# rainage V\_1.pdf Markup Summary

SP-19-001

PREPARED BY:

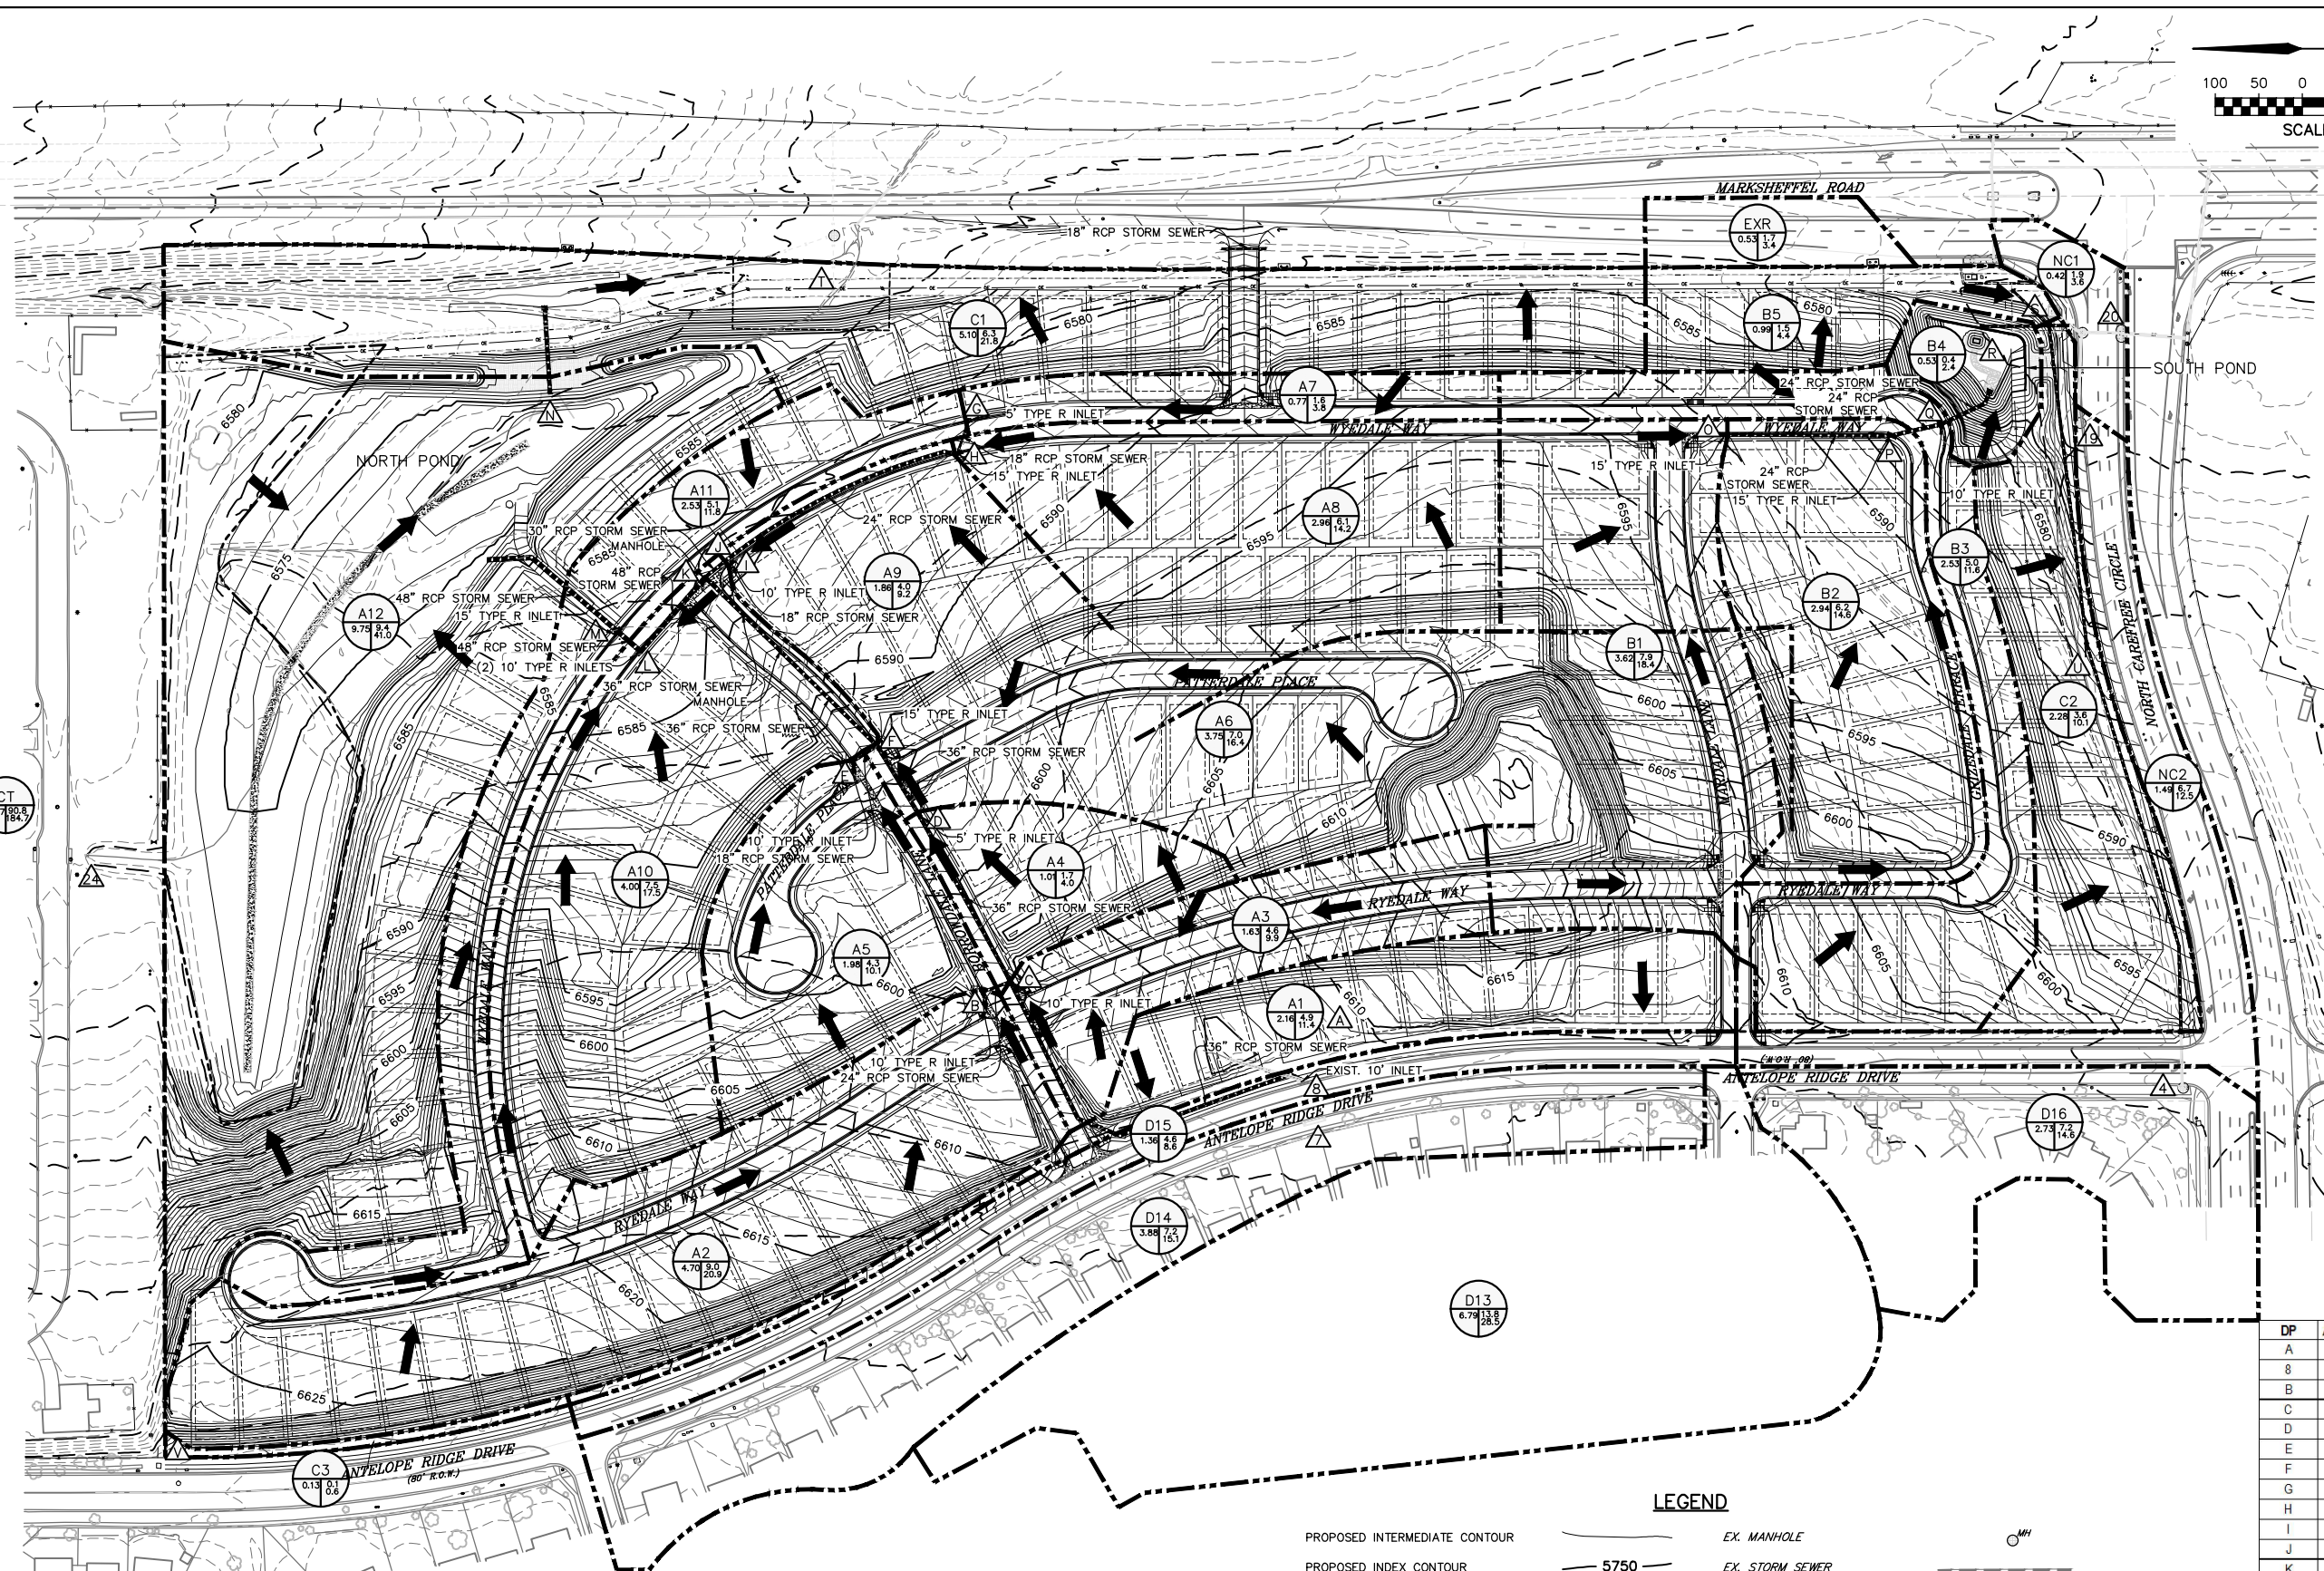
Include this area to size proposed culvert.

Proposed

Provide Existing plan,

Split onto 2 or more sheets to show adequate detail.

Address this culvert.

Show and label all easements.

What is this line?

Show and label ditch.

Provide all DPs
